Planning reference: 3/2025/0873

Location: Land at Springwood Drive, Whalley, BB7 9XL

Proposal: Construction of six detached dwellings with associated parking and landscaping at land off Springwood Drive

We refer to the latest letter from the Environment Agency dated 26th May 2026 in which the Environment Agency maintained their objection to the planning application as the Environment Agency are not yet satisfied that the development would be safe without exacerbating flood risk elsewhere. The reasons being given are below along with our responses.

**EXISTING SITE PLAN**

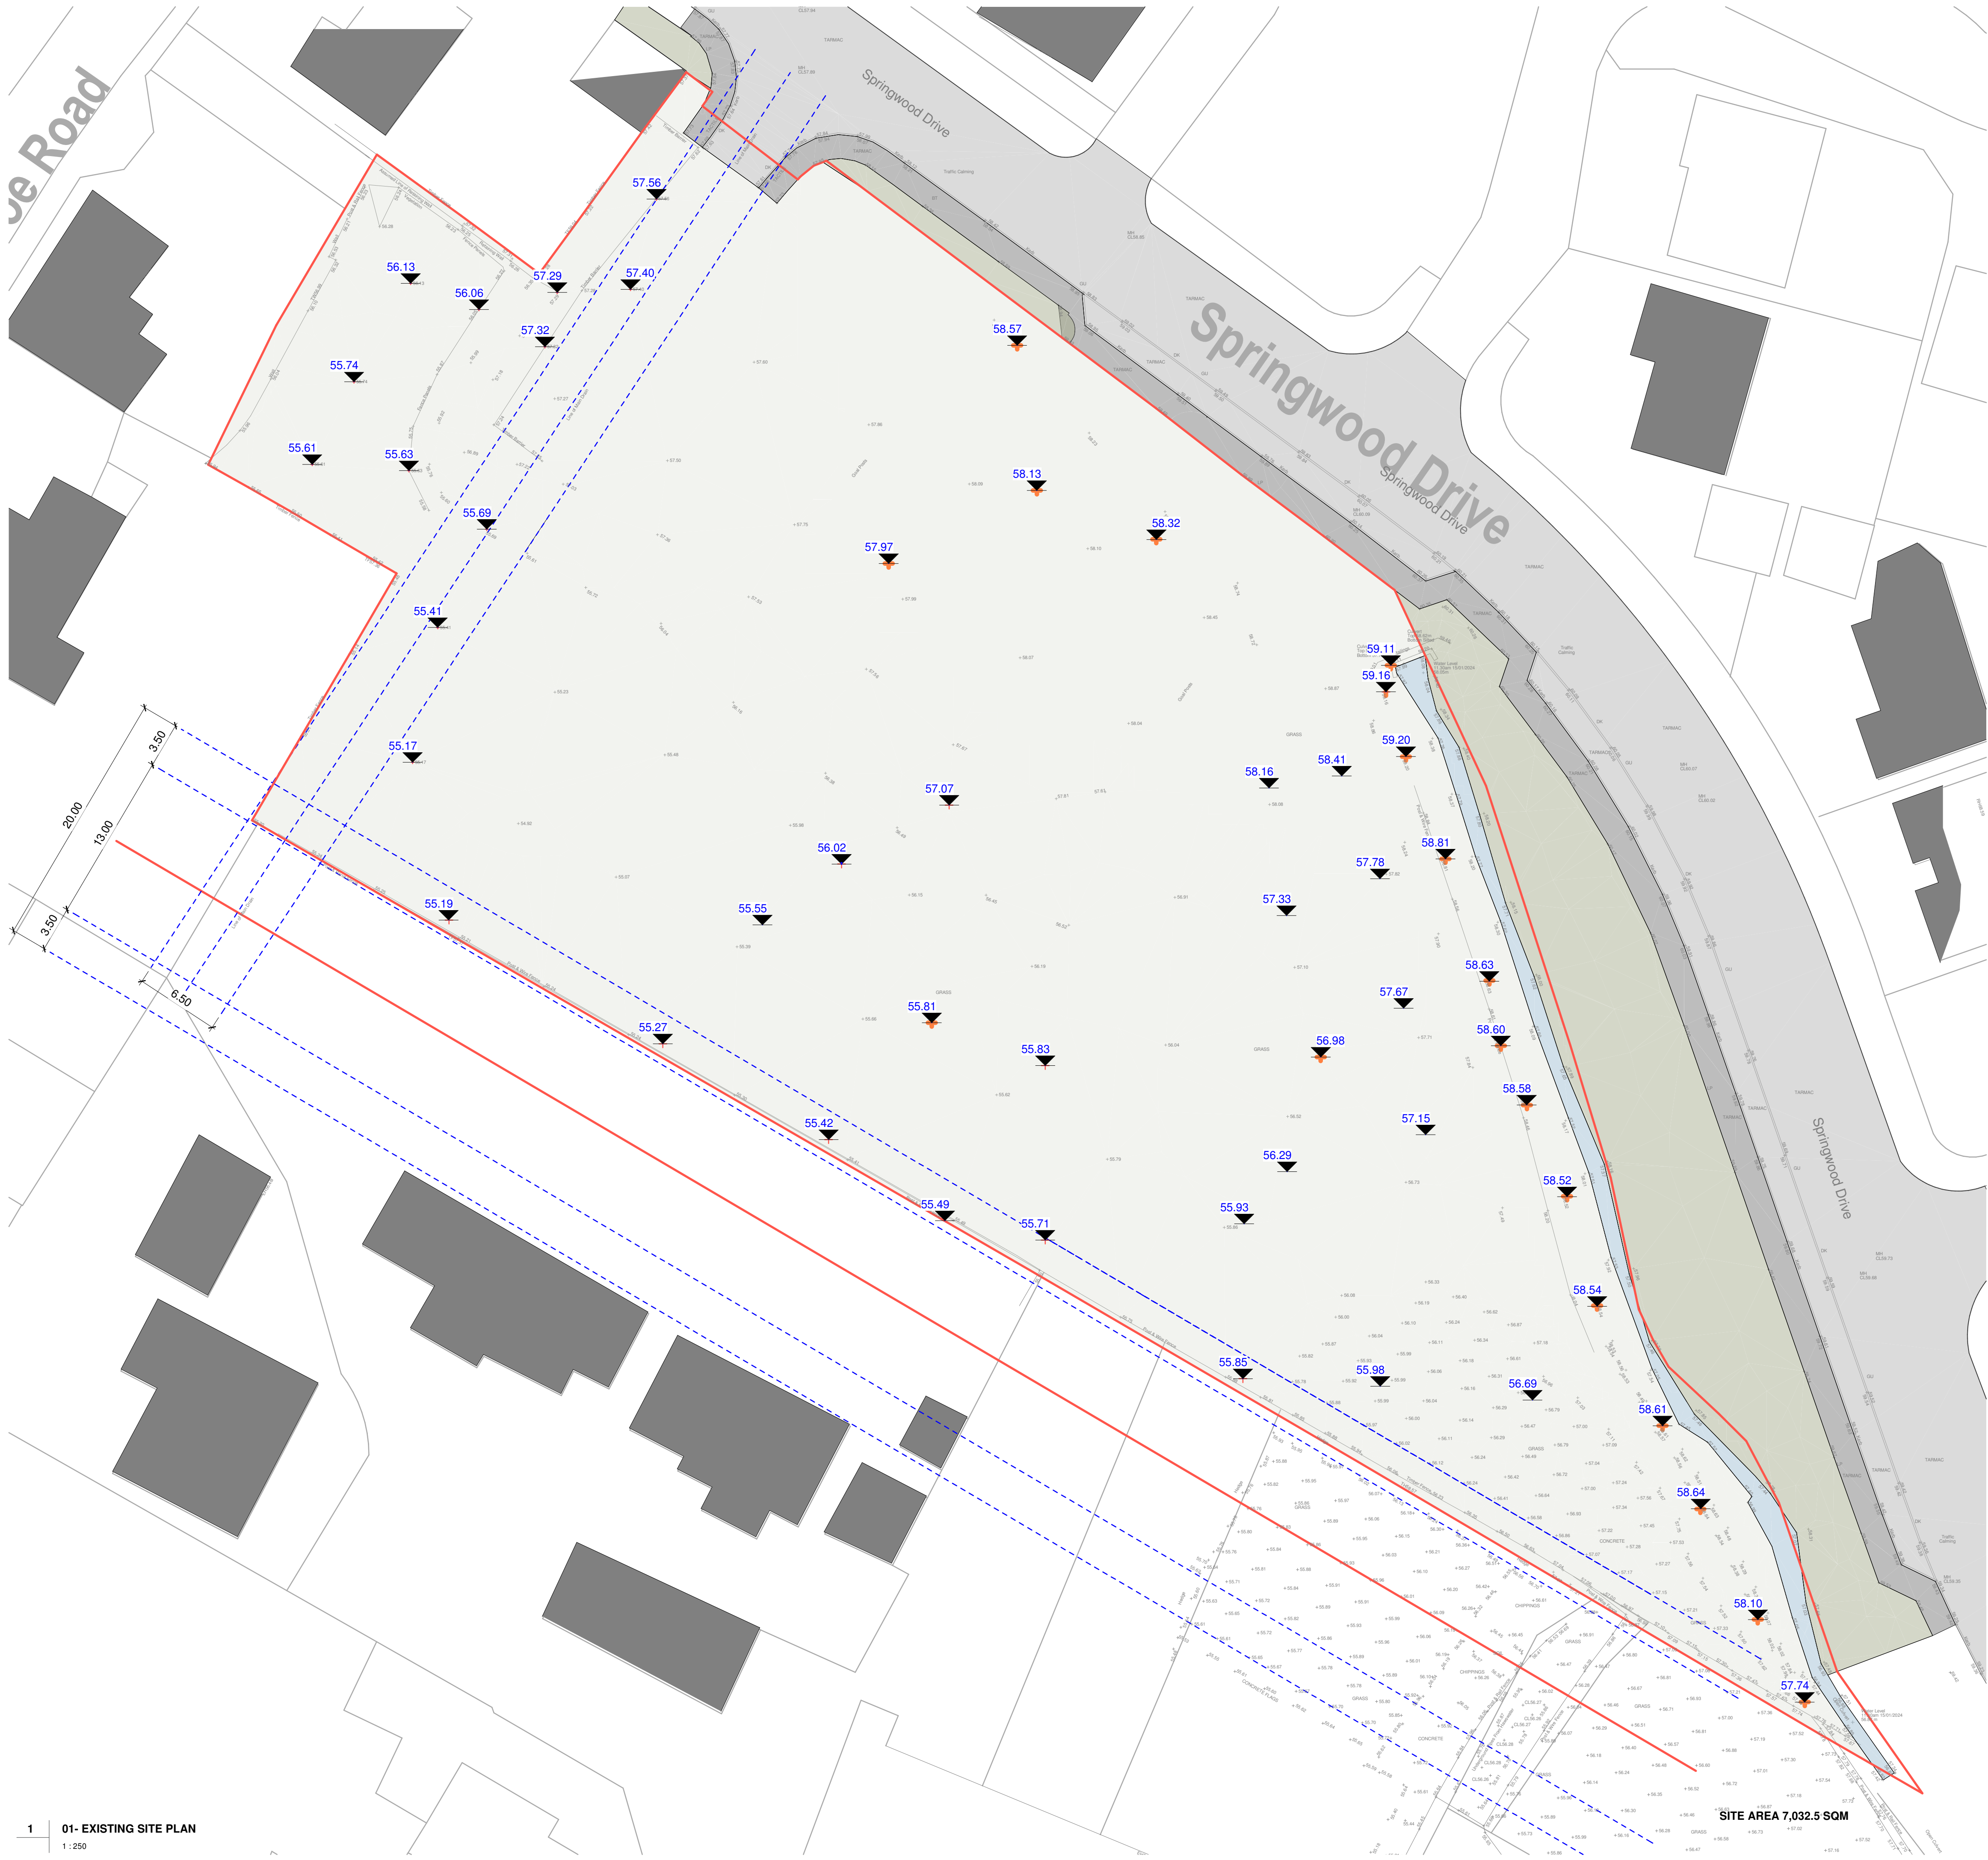
At the request of the Environment Agency, in addition to what was already a detailed topographical survey, a more intense grid of levels has since been provided, to the stretch of the western bank of the Wiswell Brook where overtopping is alleged to occur on the Whalley 2017 model, i.e., the south-east of the site.

The information from the survey demonstrates, in unequivocal terms, that there is no low spot within the western bank which would cause flooding from the Wiswell Brook into the development site. As such, any water within the Wiswell Brook stays within the channel and does not overtop the western bank into the development site even when the 0.1% AEP event is considered, (i.e. during the design flood event – the 0.1% AEP event being used as a ‘proxy’ for the 1% AEP plus climate change event), and which has always been the situation.

However, approx. 5m to the south of Node Reference 931620 in the extreme south eastern corner of the development site, the additional topographical survey has identified a low spot within the western bank where there may be a plausible flow path for floodwaters to overtop the western bank of the Wiswell Brook during the 0.1% AEP event.

The detailed topographical survey was provided with our earlier letter and part has been attached to this letter. Importantly, it has been marked up to show that any potential overtopped floodwaters, should they occur at the location approx. 5m to the south of Node Reference 931620, i.e., in the very extreme south eastern corner of the development site, will not ‘fan out’ into the Flood Zone 2 extent at the south of the site where ground level raising is proposed. When correctly interpreting the existing ground levels it can be seen from the marked up survey that the potential for any overtopped floodwaters will flow away from the development site (the limit of the southern site boundary is defined / confirmed by the red line on the topographical survey). The downward gradient of the natural slope of the land away from the proposed development is very evident and therefore any potential flood routing will not be routed back to the south of the development site.
